## **Comments by Allow Ltd upon TN 8.22**

### **‘Assessment of Alternative Locations for Mitigation in Plot 5/2’**

**Response Deadline 5 20<sup>th</sup> Jan 2021**

Drawing Title  
**FIGURE 3.2  
 OPTIONS TO THE EAST  
 OF DARK LANE**

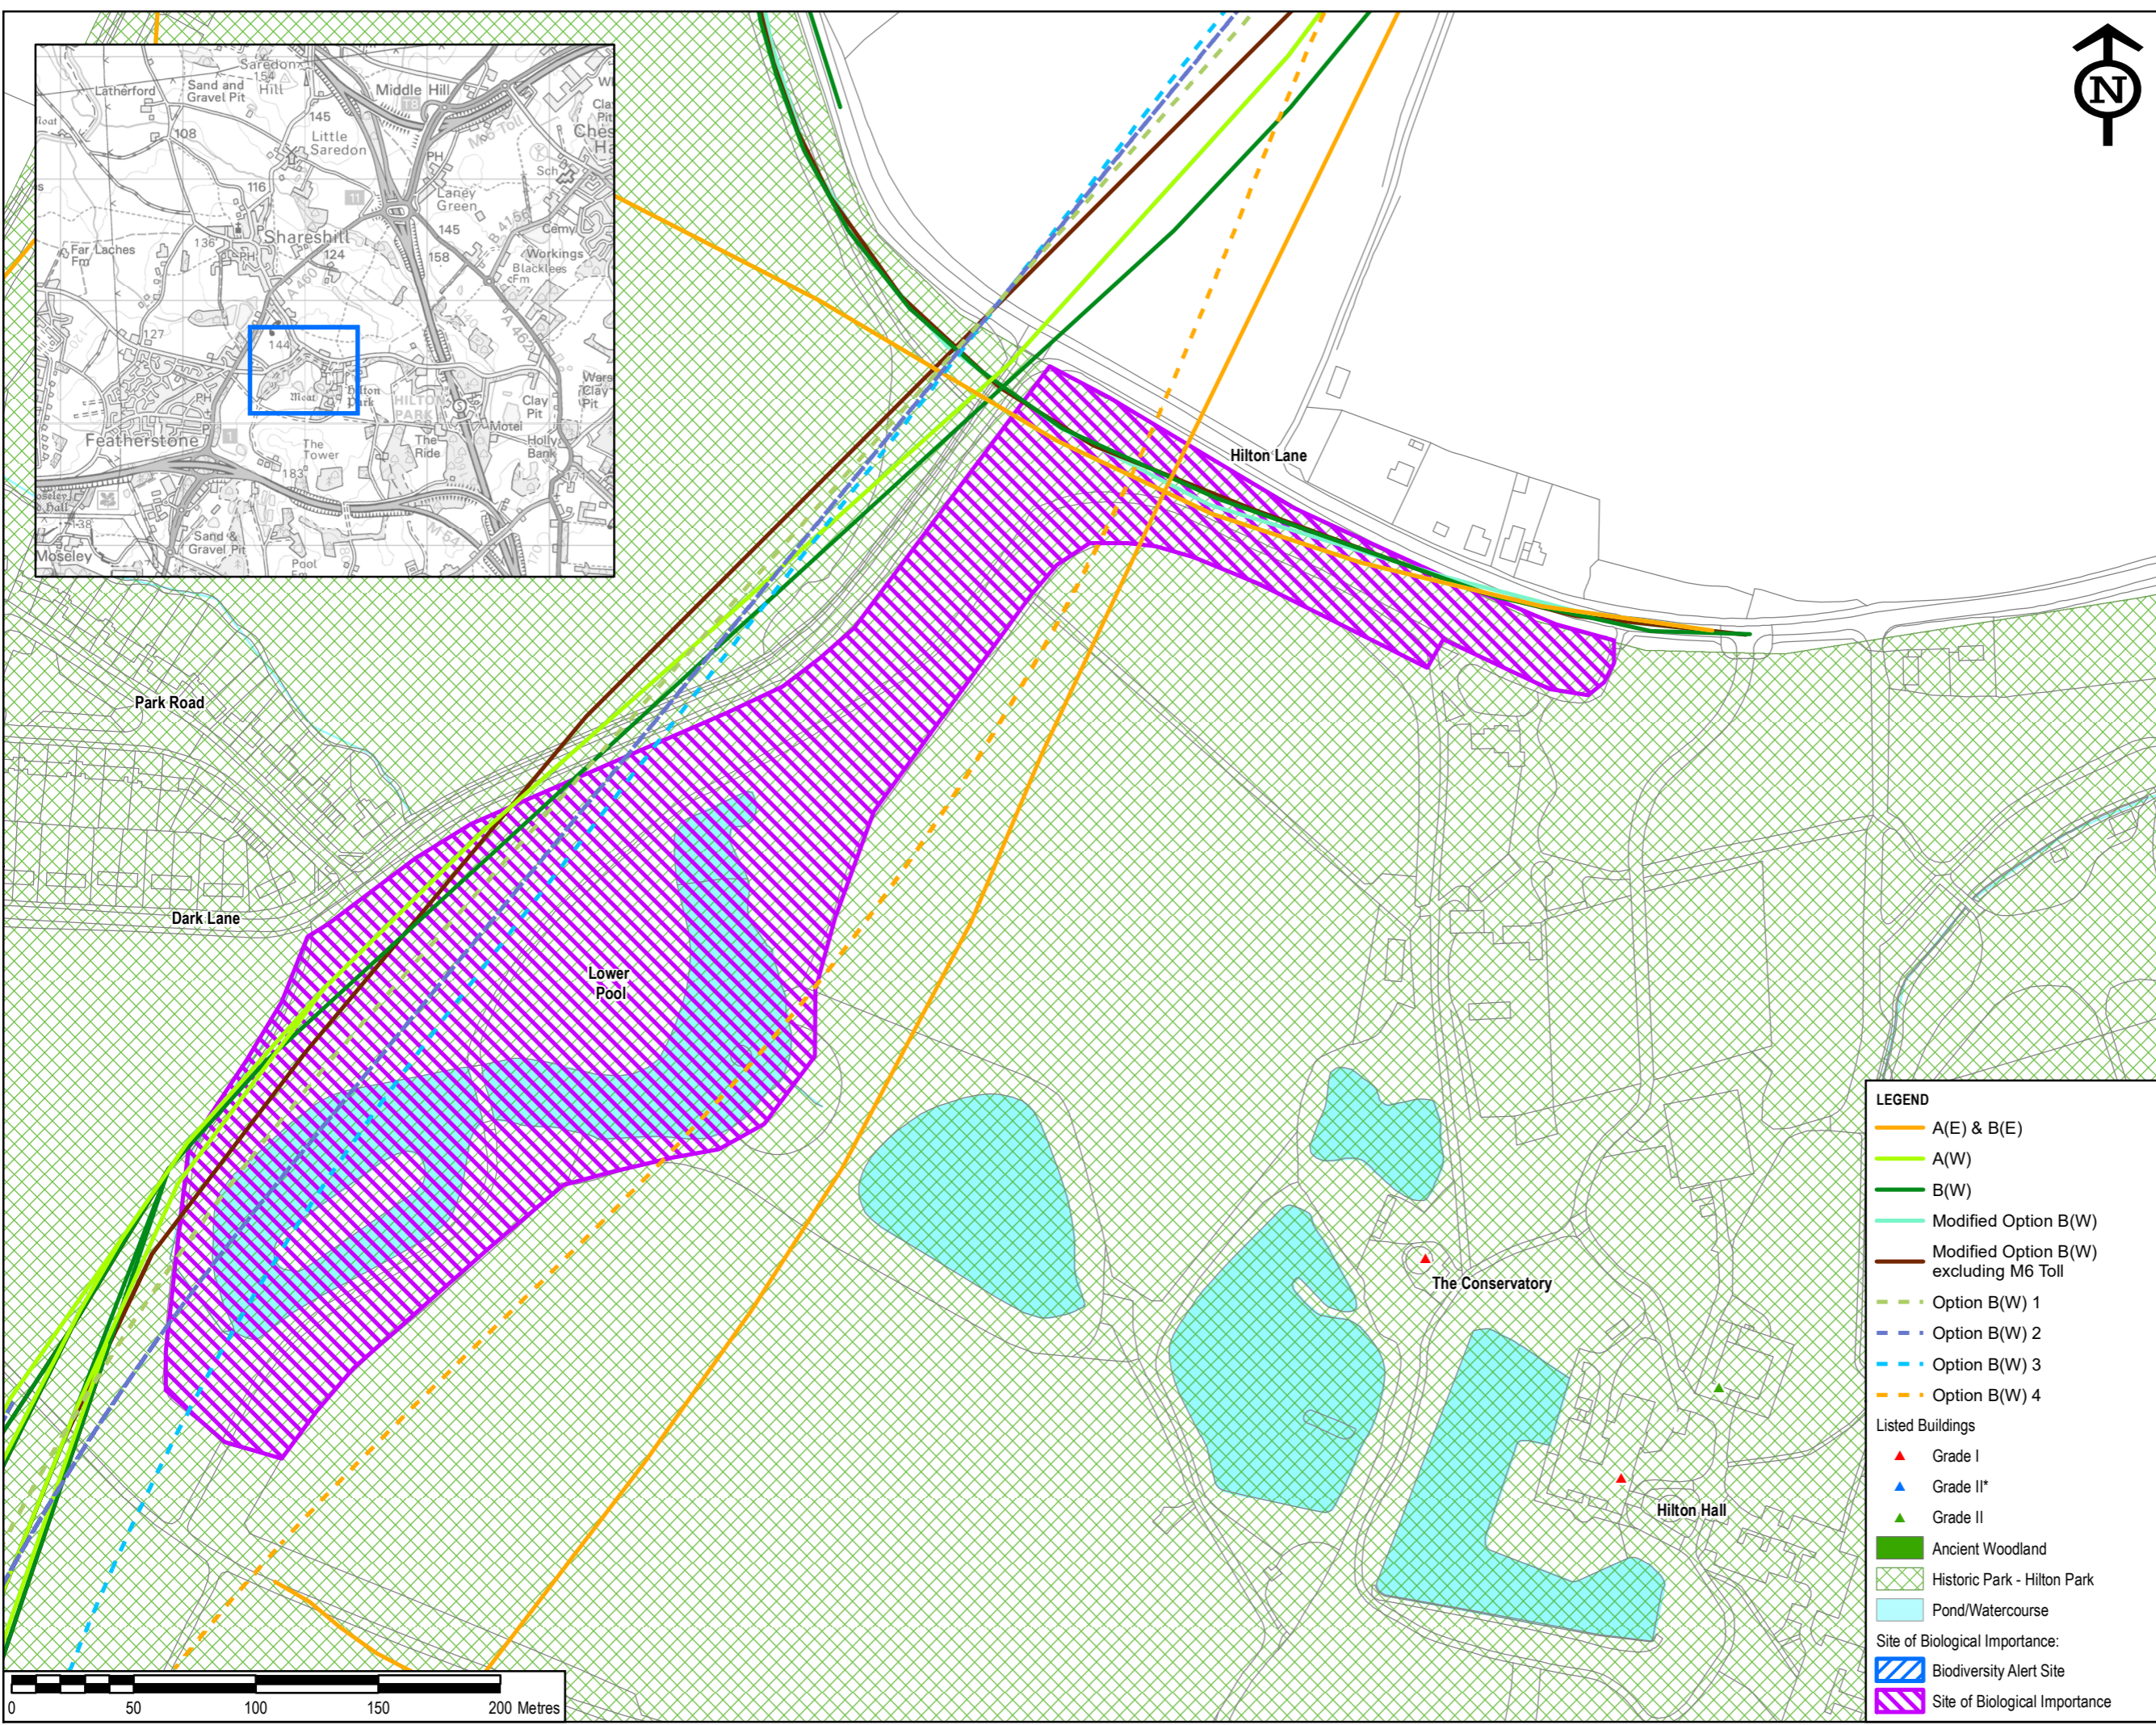
Section 3 - The proposed planting layout drawn up by Allow following the site visit with Historic England of 6<sup>th</sup> January is much better than either of the two options for planting to the east of the road as shown in this TN and reflects views shared with Historic England at the site meeting.

Section 4 – The thrust of the Applicant’s argument is that planting to the east of the road (their Options 2-4) would increase the magnitude of impact on the Grade I listed buildings from Minor (current Scheme) to Moderate, resulting in the significance of effect in each case being Moderate (and therefore significant in EIA terms). This is looking at the significance of the Grade I listed buildings,

Para 4.2.18 – whilst we agree that bats are less likely to use woodland south of Dark Lane (in plot 4/20c), why is it considered that bolstering woodland around the Shrubbery and Lower Pool, plus creating more areas of open water (next to known roosts), will not benefit bats (leading to an overall conclusion 'slight adverse' significance)? This is the same conclusion as Option 1, but with better planting and habitat creation to the east for bats. Therefore, we question how the same conclusion as that for Option 1 has been reached.

Para 6.1.3 – The applicant appears to not be including the potential benefit to bats provided by the proportion of woodland planted to the east of the scheme in Option 3. They are just focusing on the section of woodland in 4/20c.
